GREENER PASTEURS, LLC
 7280 NEVADA LANE
 PPR 2411
SITE DEVELOPMENT PLAN AND PARKING PLAN

GREENER PASTEURS, LLC
 7280 NEVADA LANE
 PPR 2411
SITE DEVELOPMENT PLAN AND PARKING PLAN

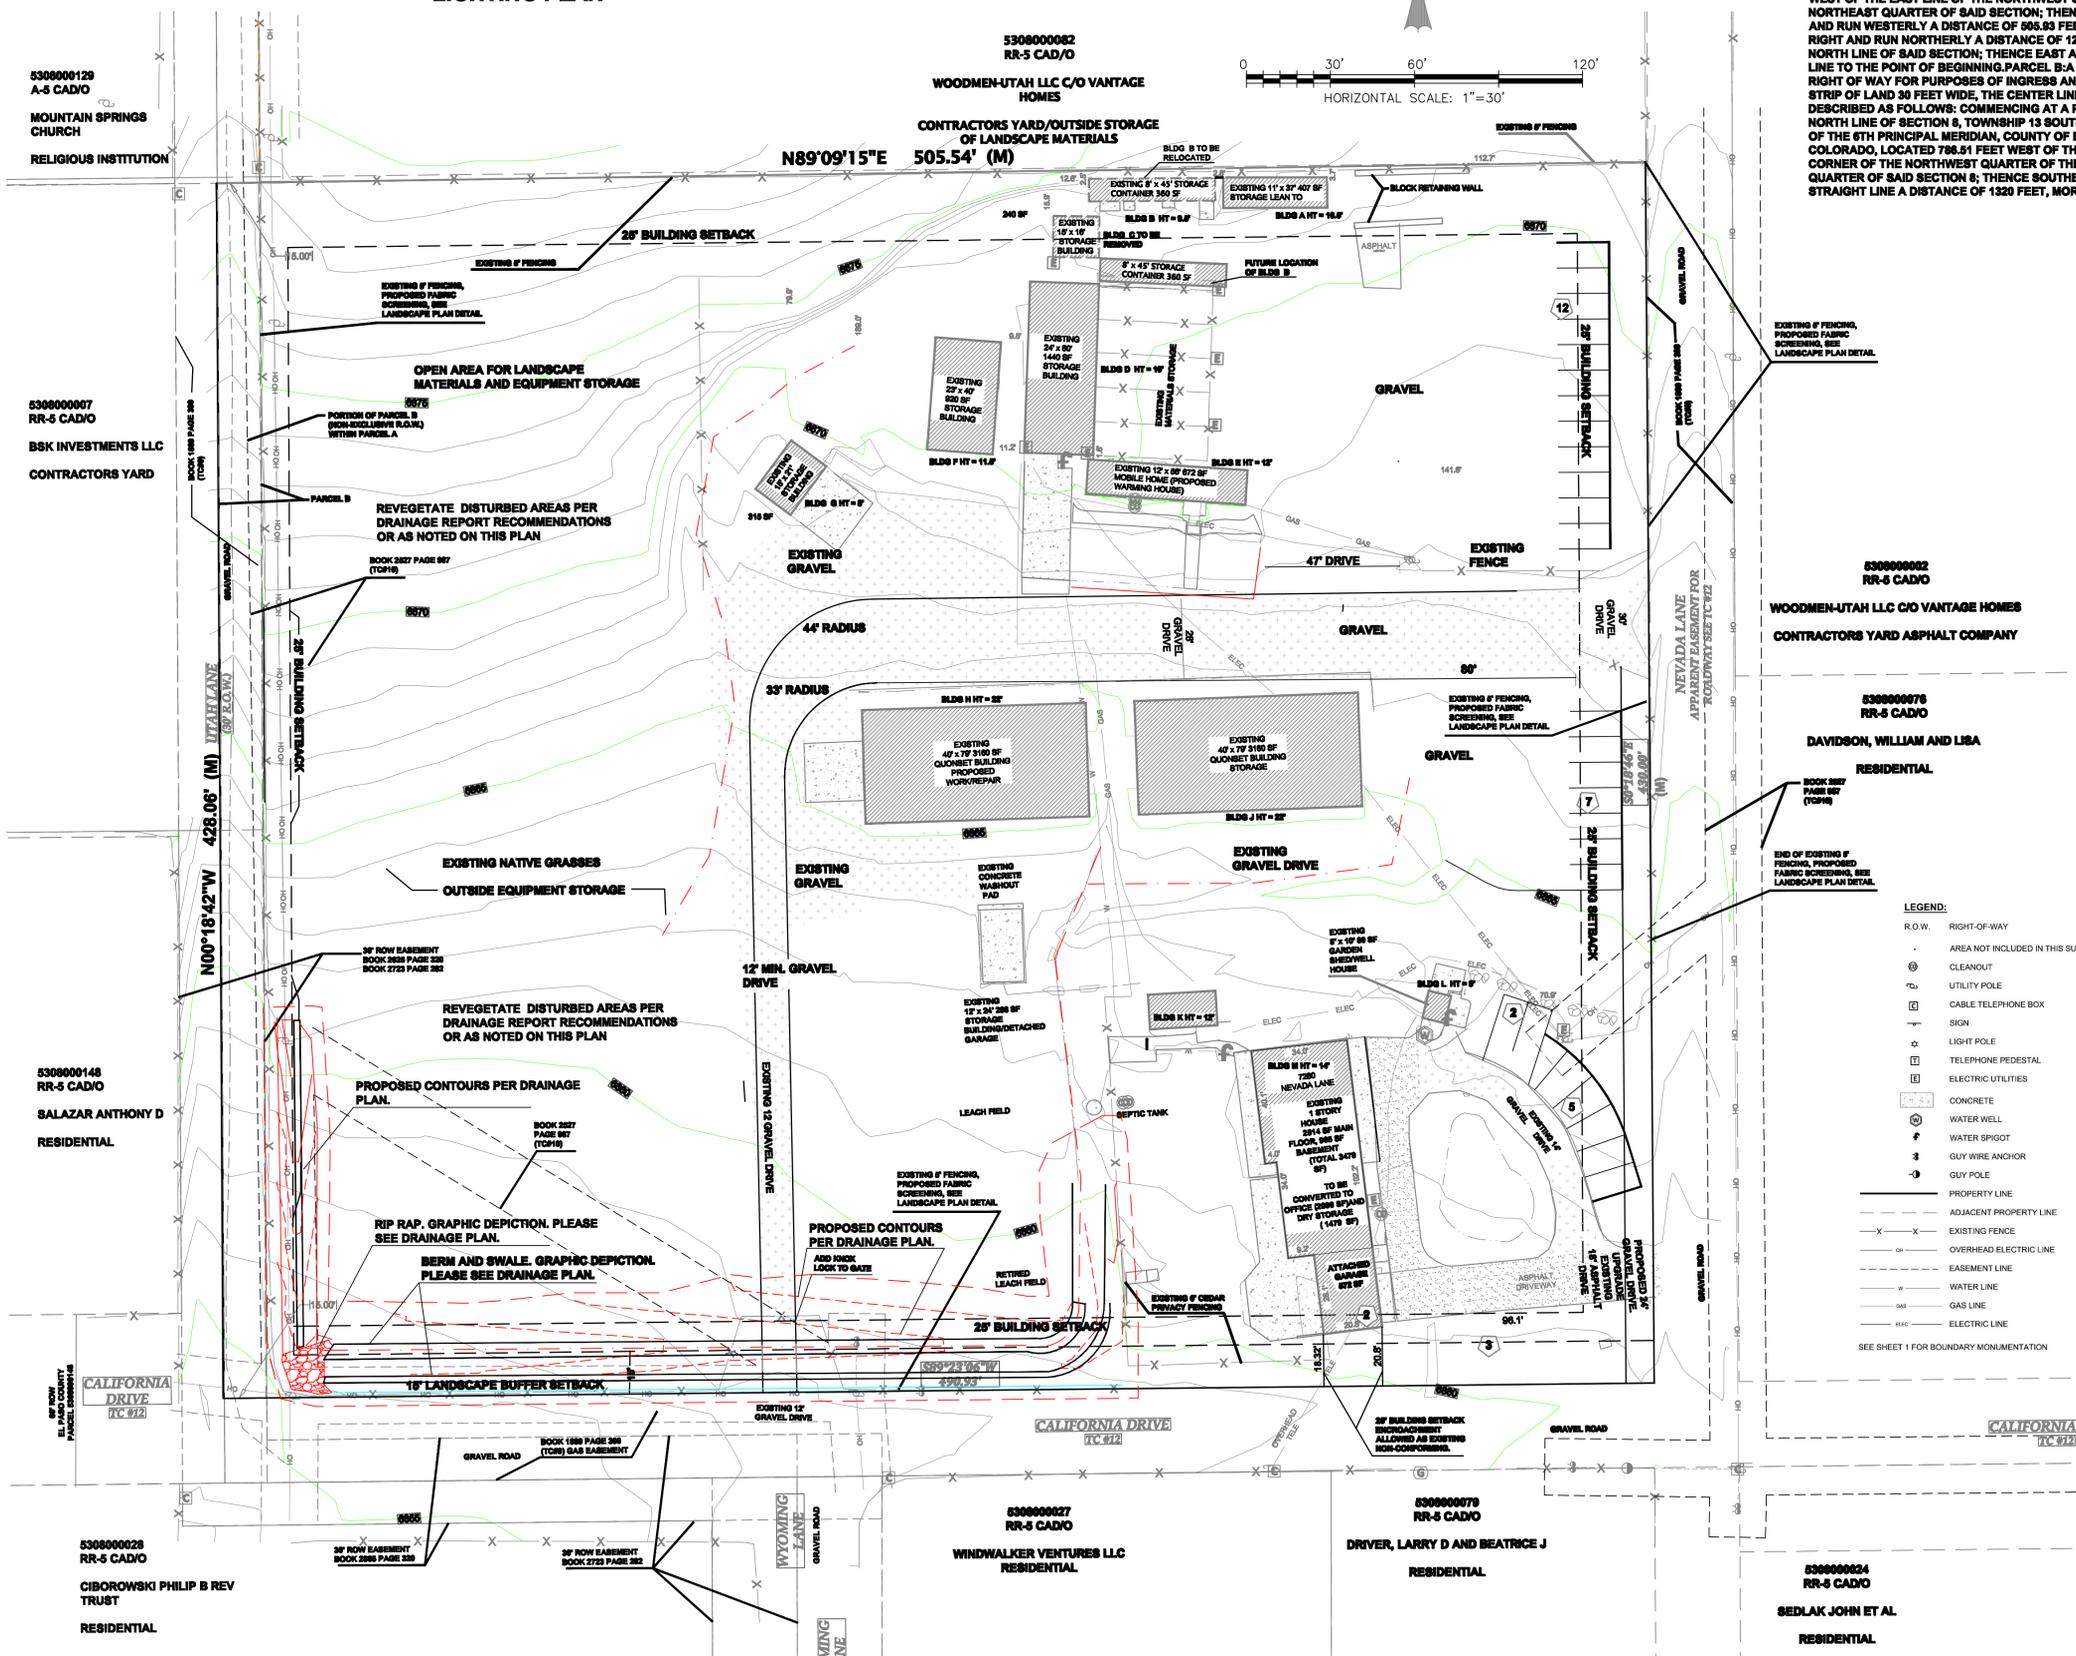
Show revegetation of bare areas.

Since a pond is being installed but the proposed disturbance is <1ac, below is the condensed list of additional documents that need to be submitted for review (the planner will send an upload request):
 - ESQCP
 - FAE
 - FAC
 - GEC Plan (include pond details)

Erosion protection is required at all potential pipe such as level spreader. Note that concentrated discharge directly onto California Dr. - the dirt roadway can cause erosion.
